Planning Application – Alloways, 33 Shelley Road, Bognor Regis, PO21 2SN – Planning Reference BR/76/19/PL

I would like to object to the planning application for 33 Shelley Road on the following grounds:

No.	Revision/Issue	Date
Proposed Conversion Proposed Elevations Planning		
Date March 2019		
Scale 1:50

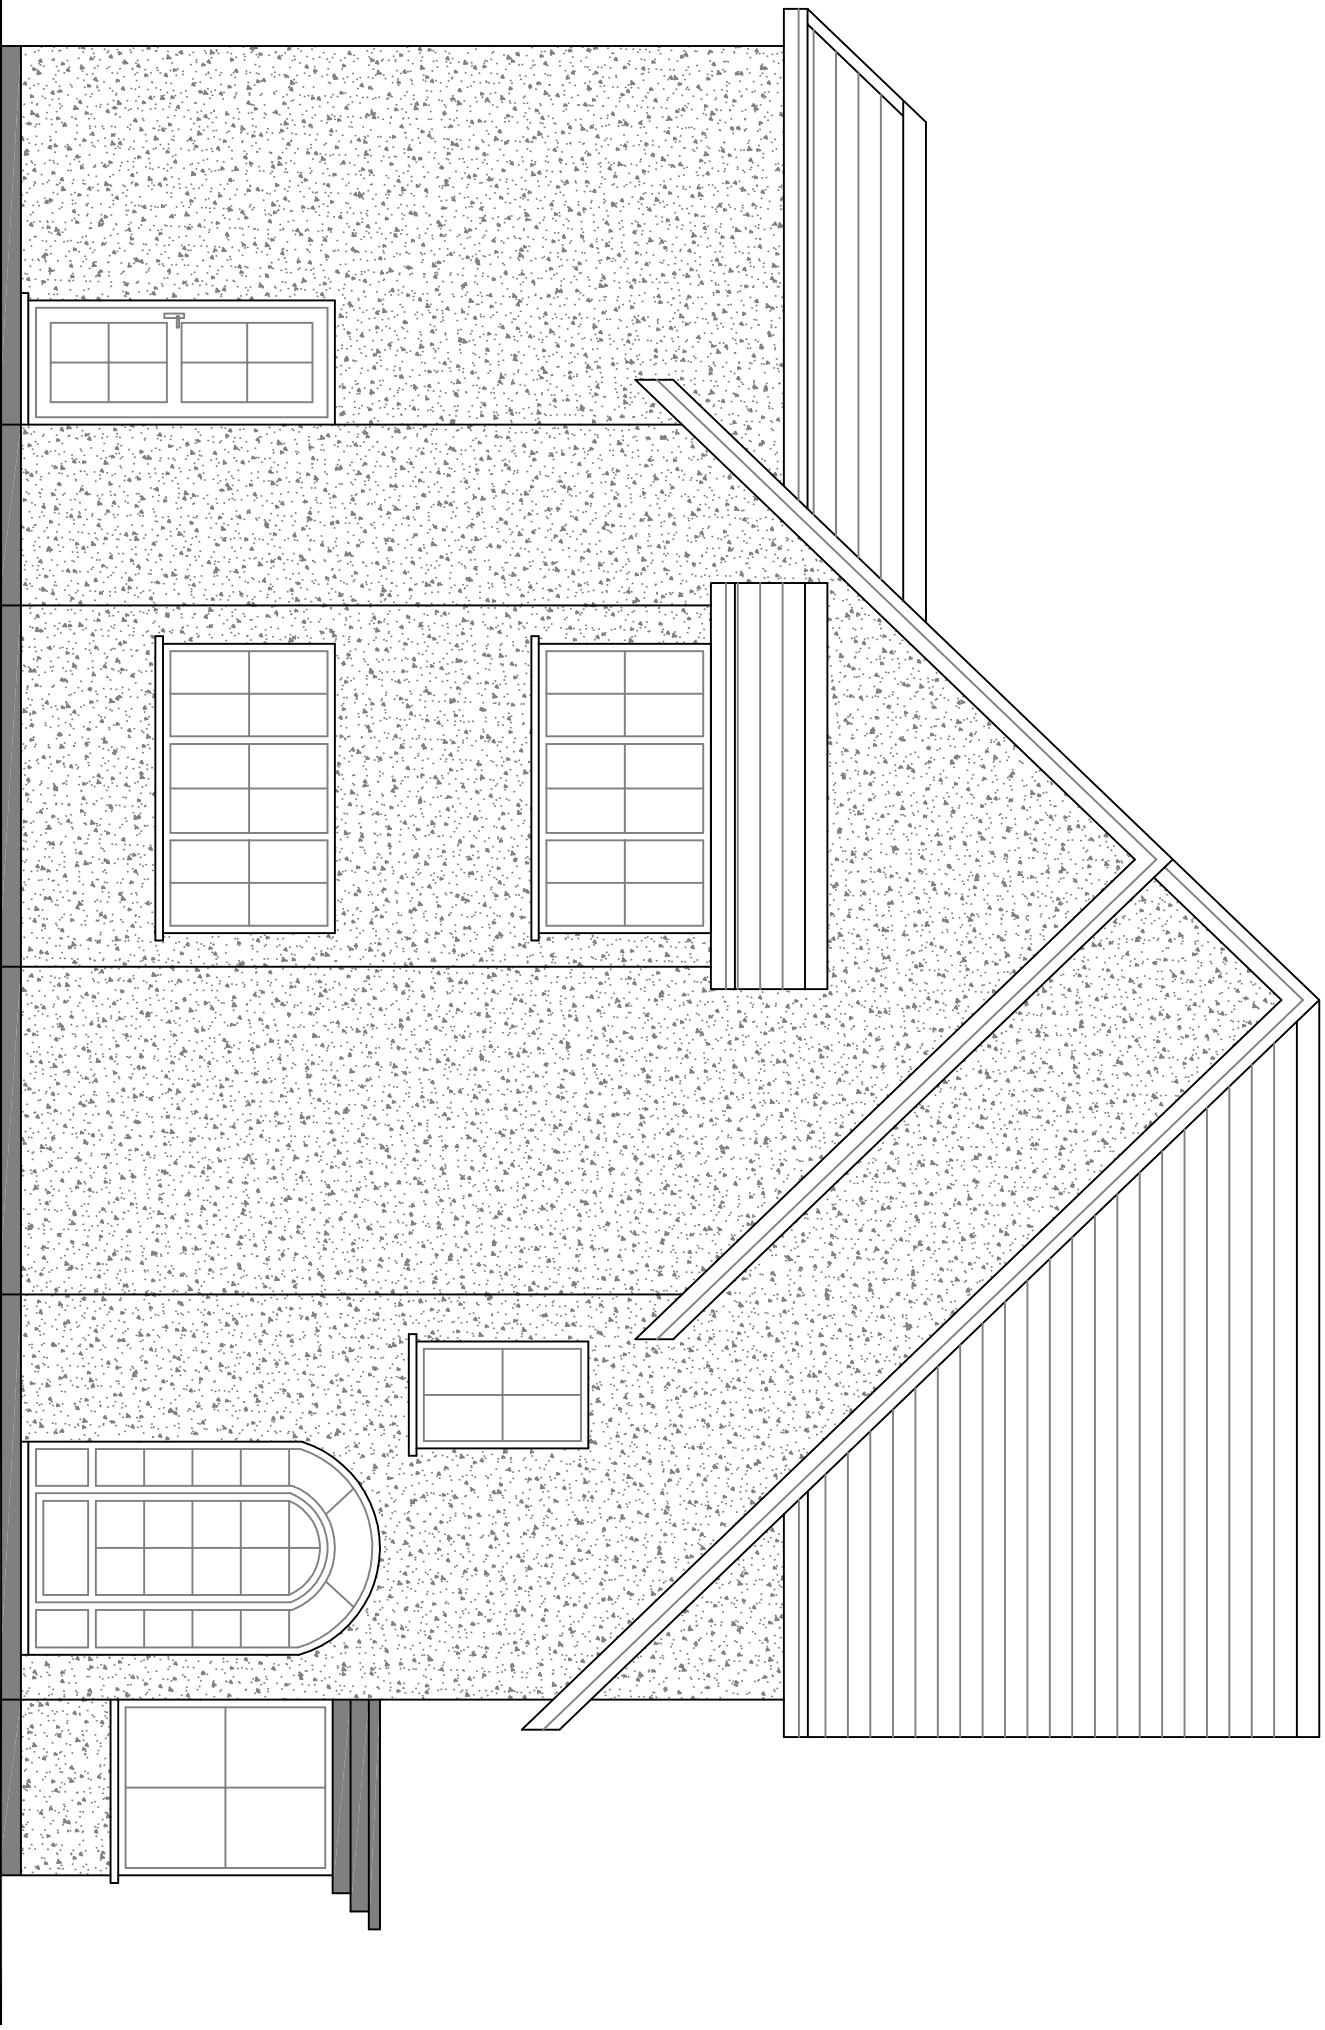
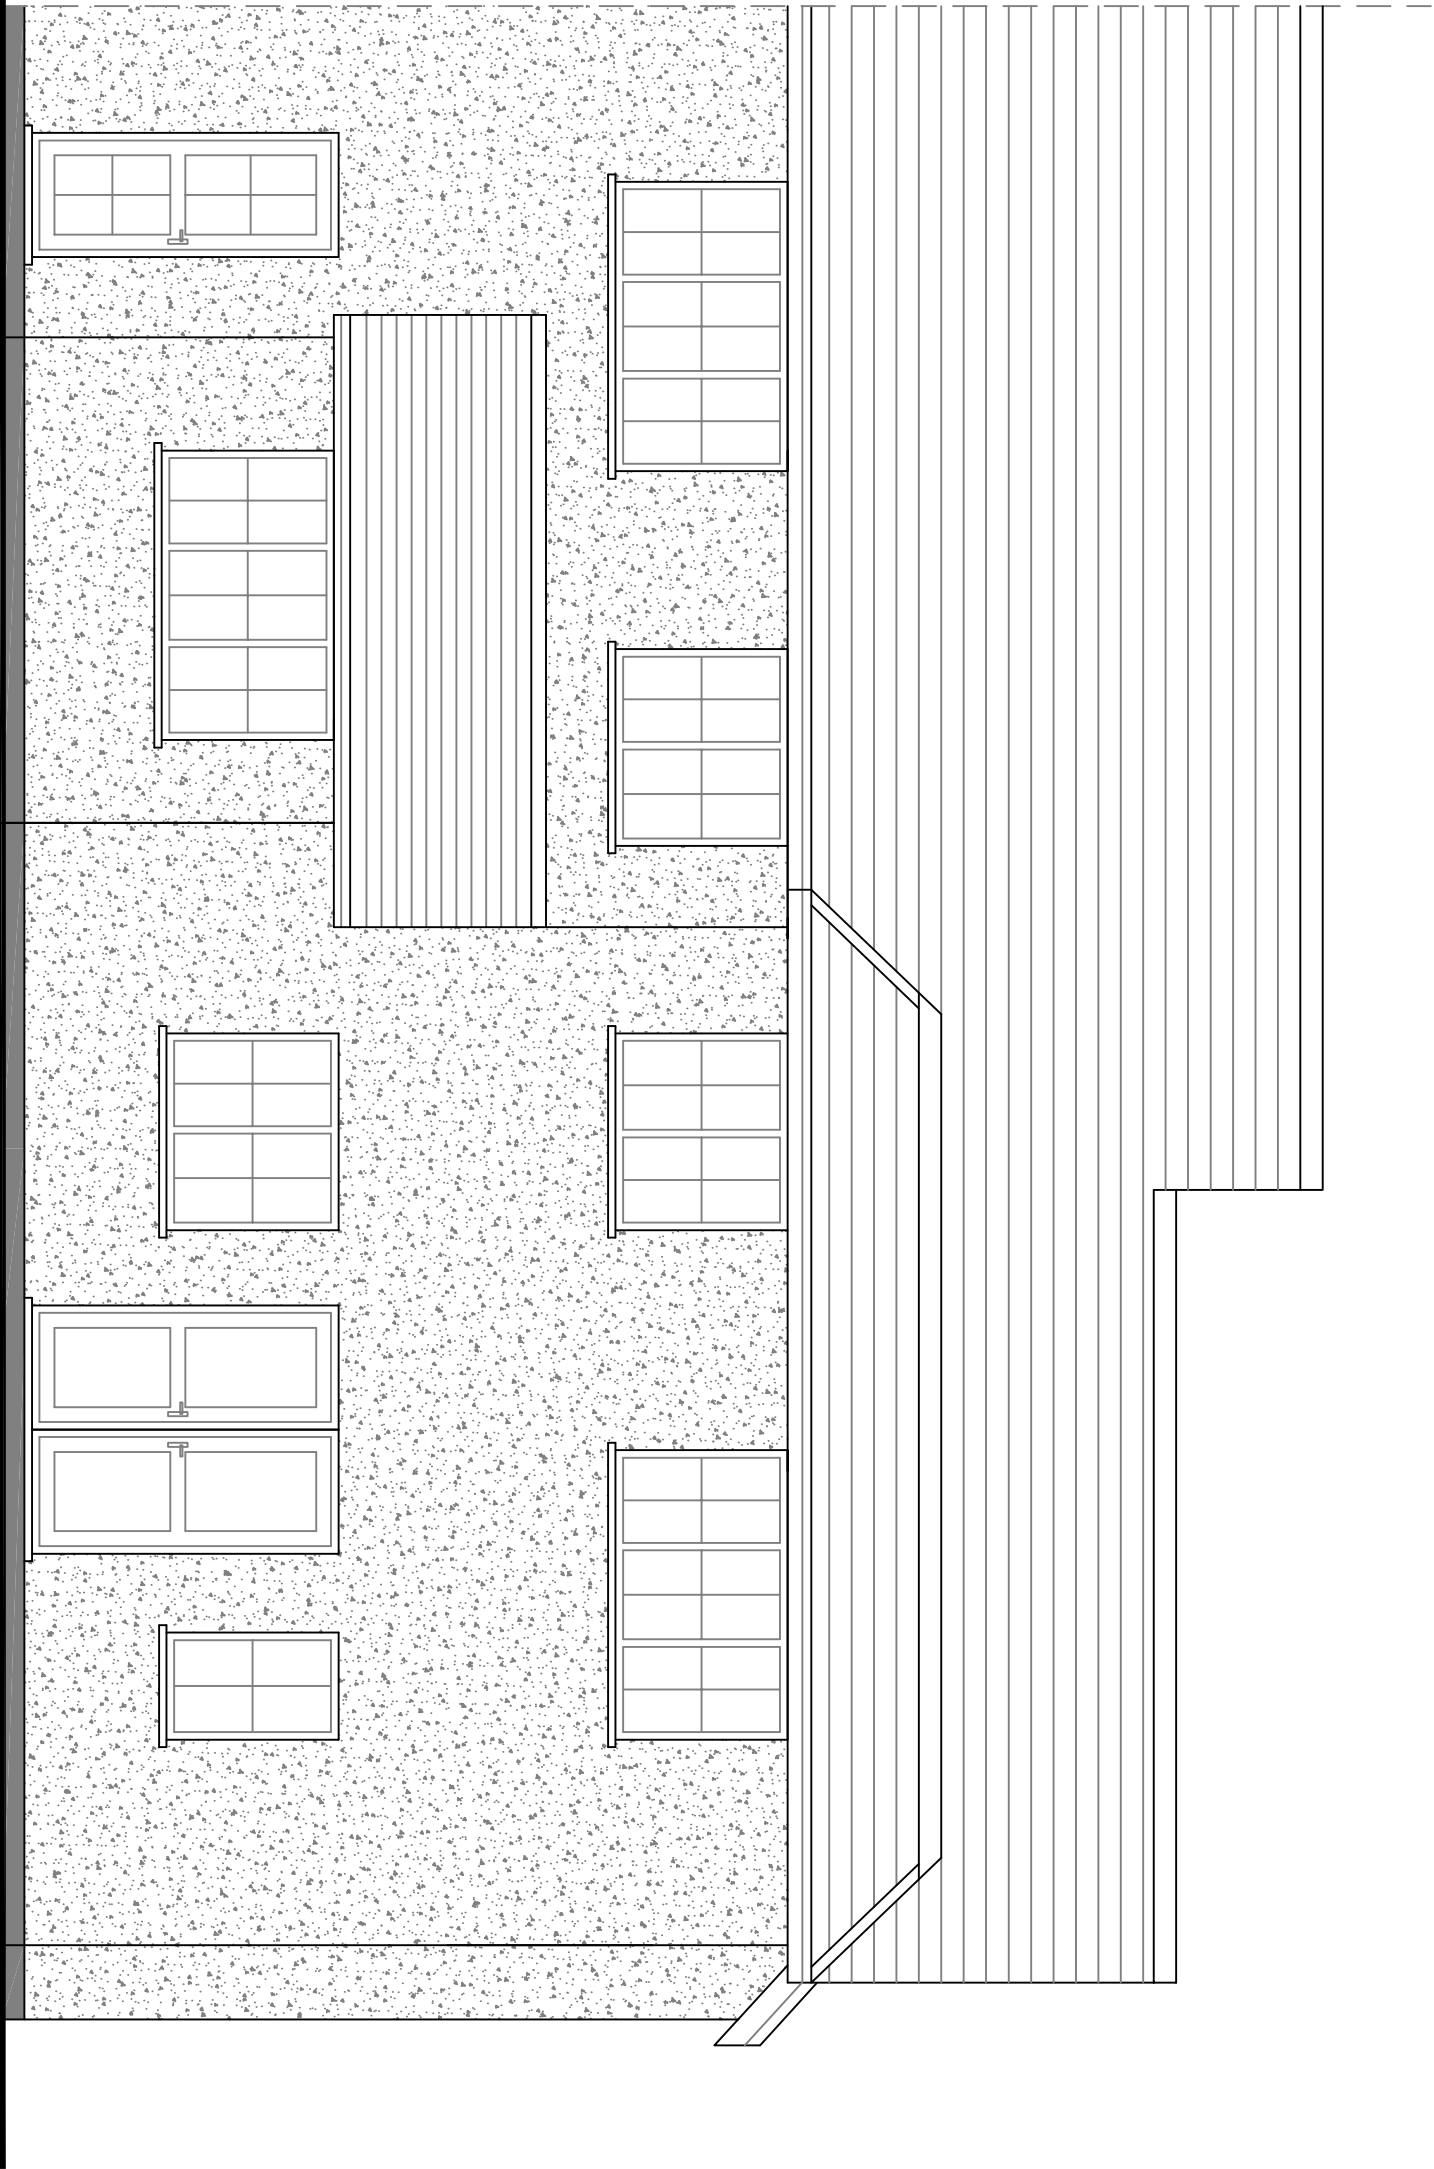
- 2) The bay window will have to be removed if two cars are to be parked in front of the house. This will destroy the façade of the house and make it out of keeping with the remaining houses in this area.

- 3) The erection of a two storey extension will reduce the amount of light that is enjoyed by the houses on either side (31 and 35). We do have right to light and not to have this reduced by the erection of an extension.
